A/231/21/PL

Land South of Water Lane Angmering

Variation of condition imposed under A/24/21/PL relating to conditions 2-approved plans, 3-approved plans, 5-flint wall & 6-landscaping.

Martyn White

FRONT ELEVATION

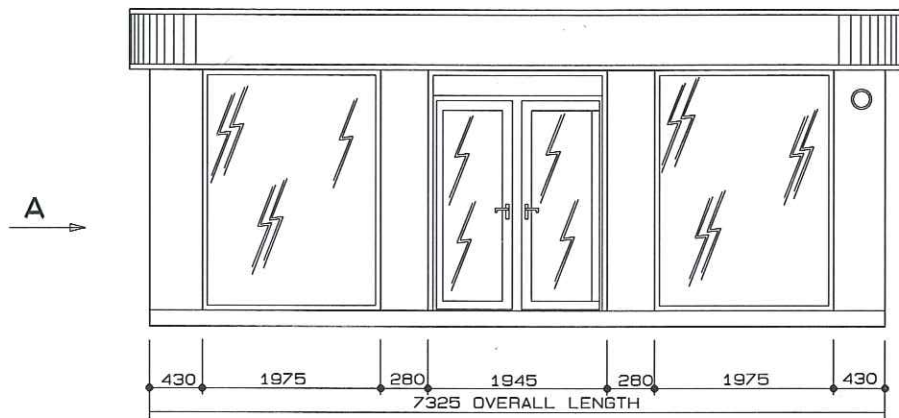
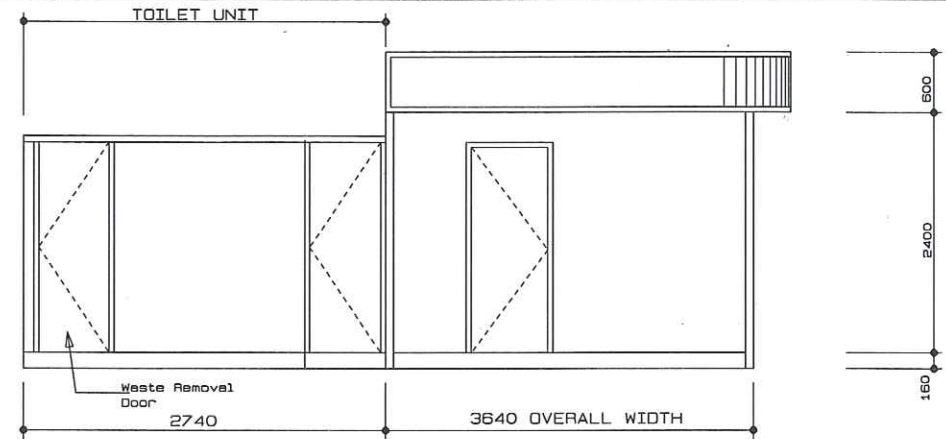
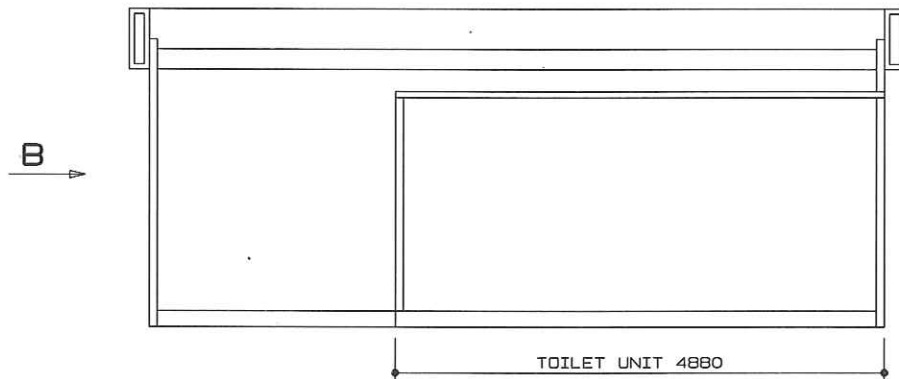
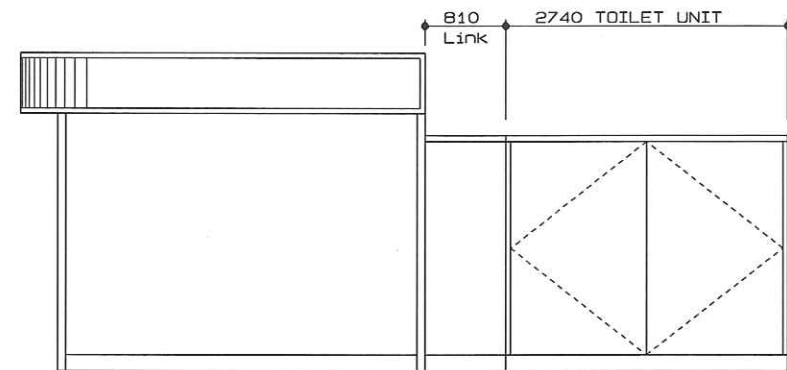
The proposed site plan indicates that the location of the temporary cabin is in an area to be landscaped and retained as open space as part of the approved development. The cabin is a fairly simple structure with glazing on the principal elevation and decorative panels on the remaining. I assume that the structure will include the companies standard branding. A scheme of landscaping has also been provided, which could attempt to soften its impact.

Drawing Title
Sales Area Layout

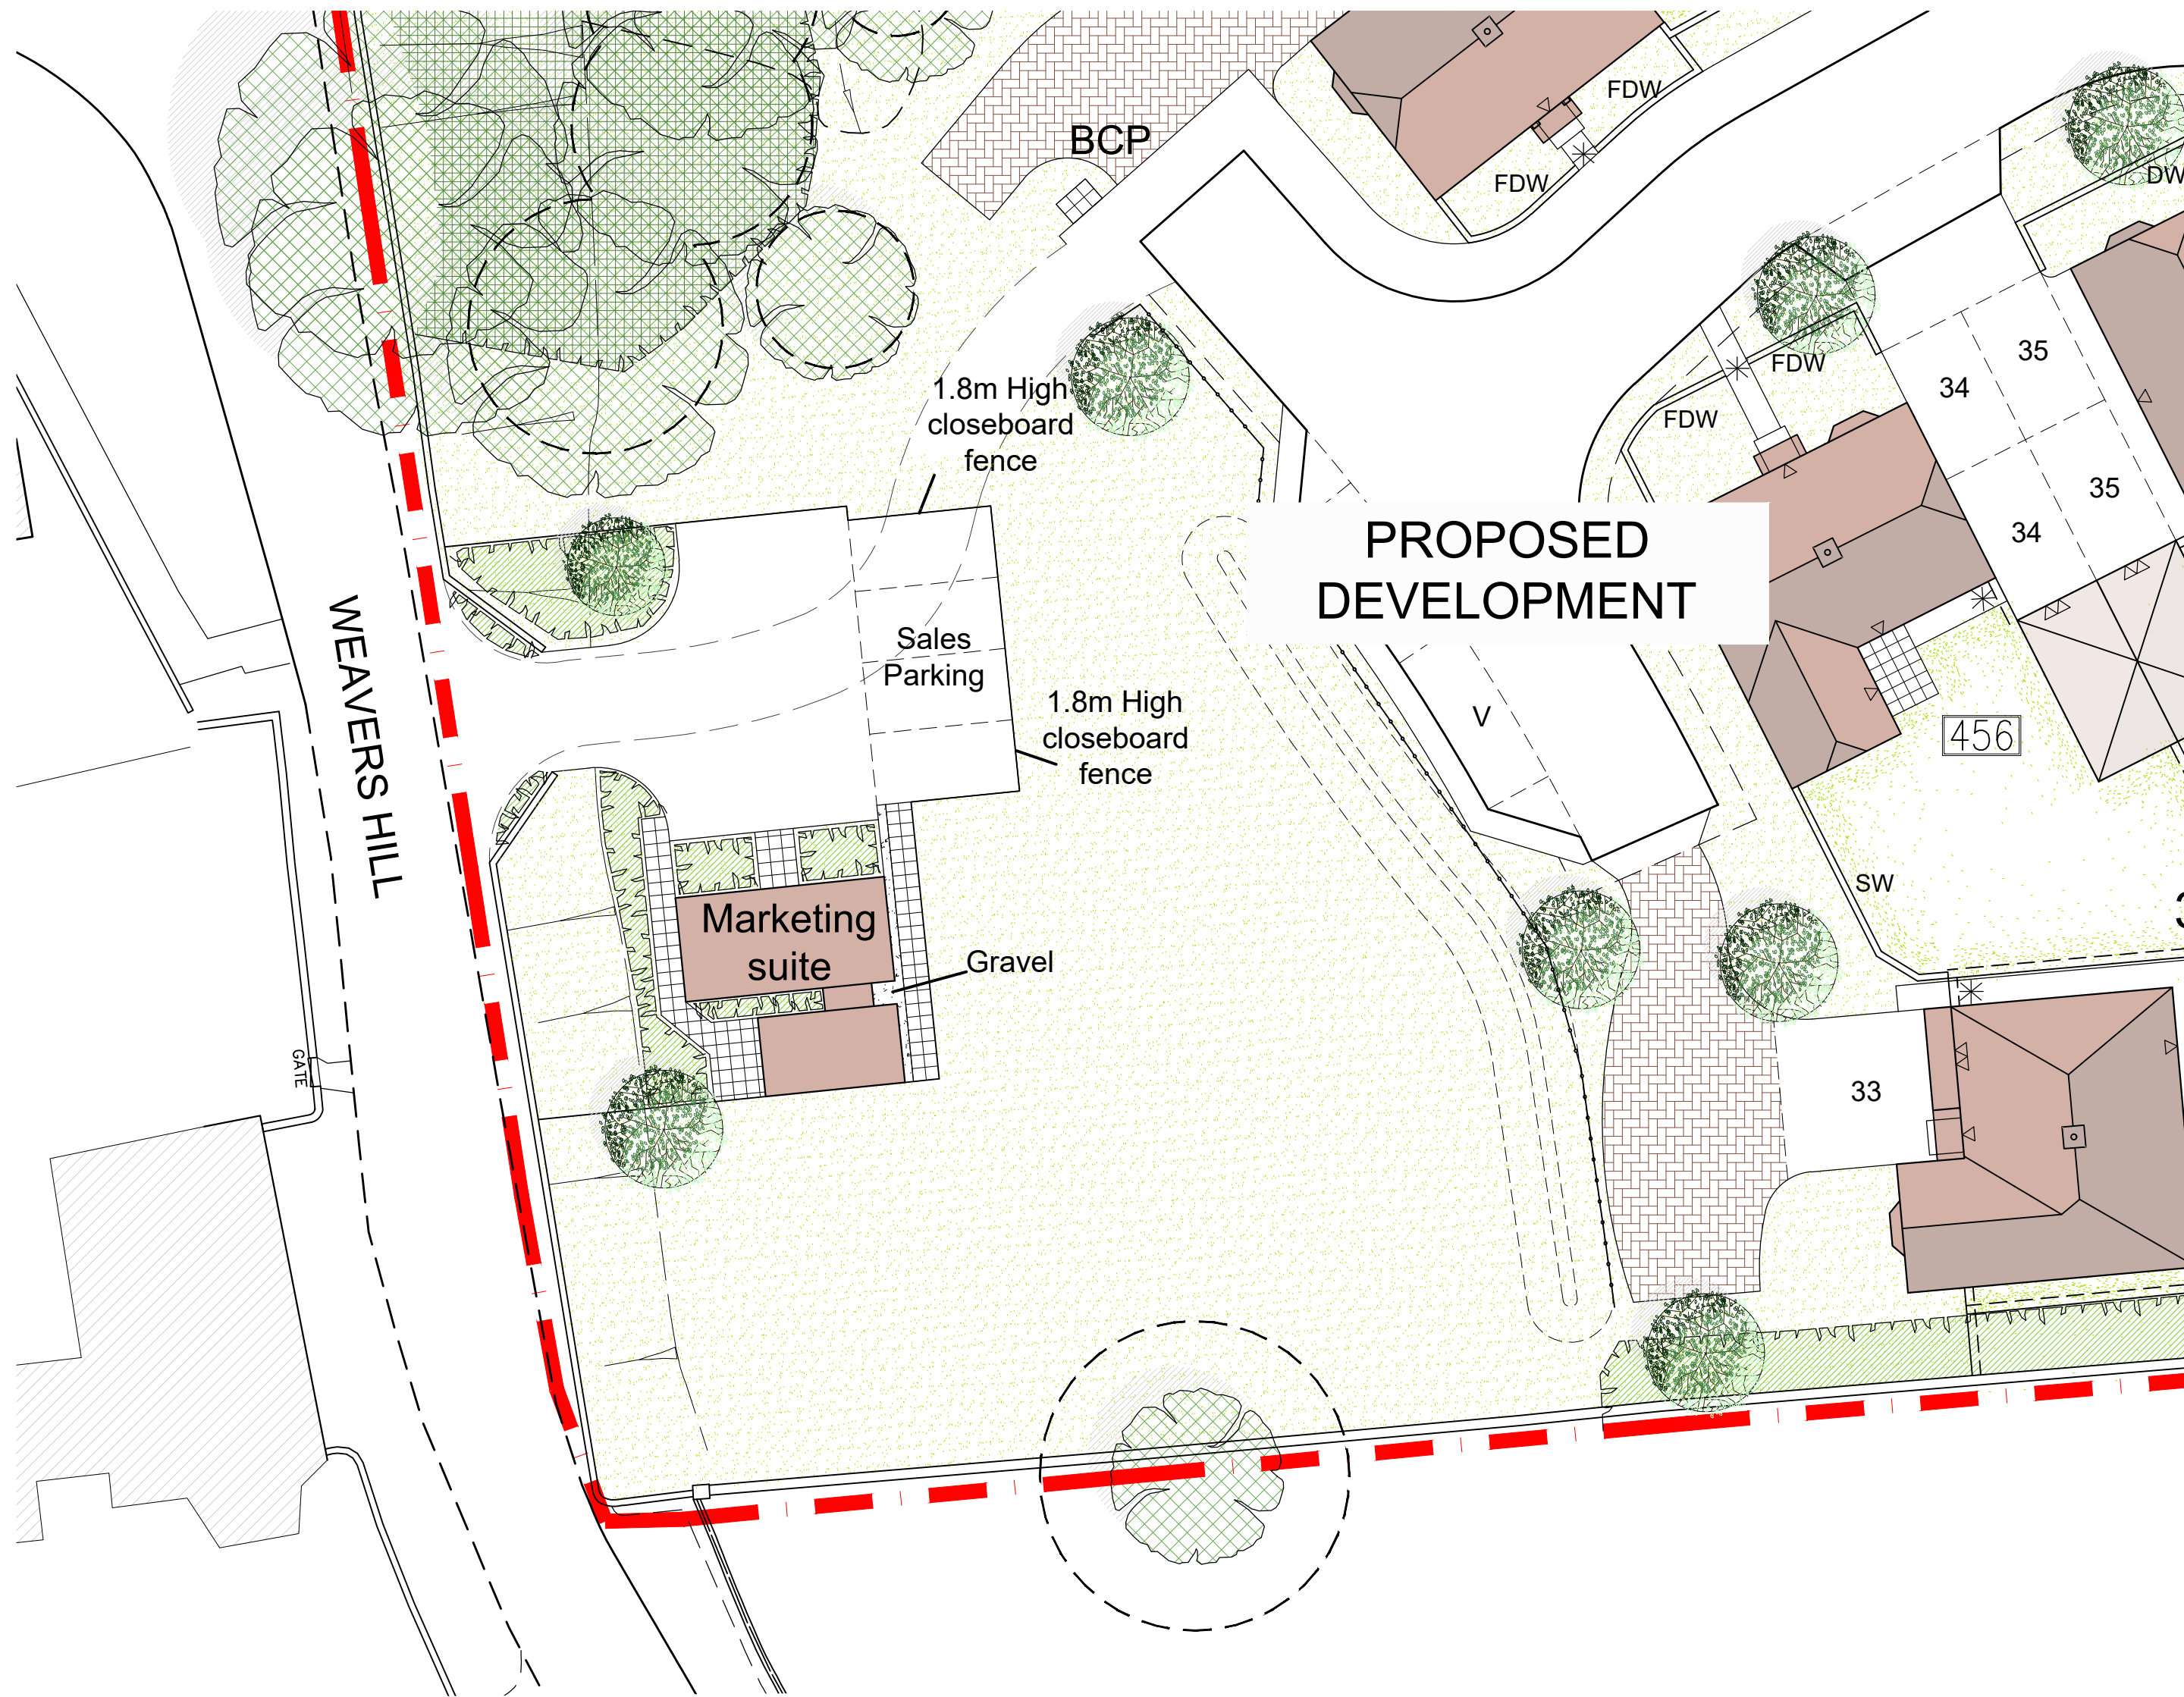
I also note that the intention is for the vehicular access to be from Weavers Hill. Weavers Hill is narrow, with the flint walling fronting almost directly onto it. It is noted that this will utilise an opening which was approved as part of the reserved matters planning application and that this application does not involve the removal of any further sections of the flint wall that has not already been consented.
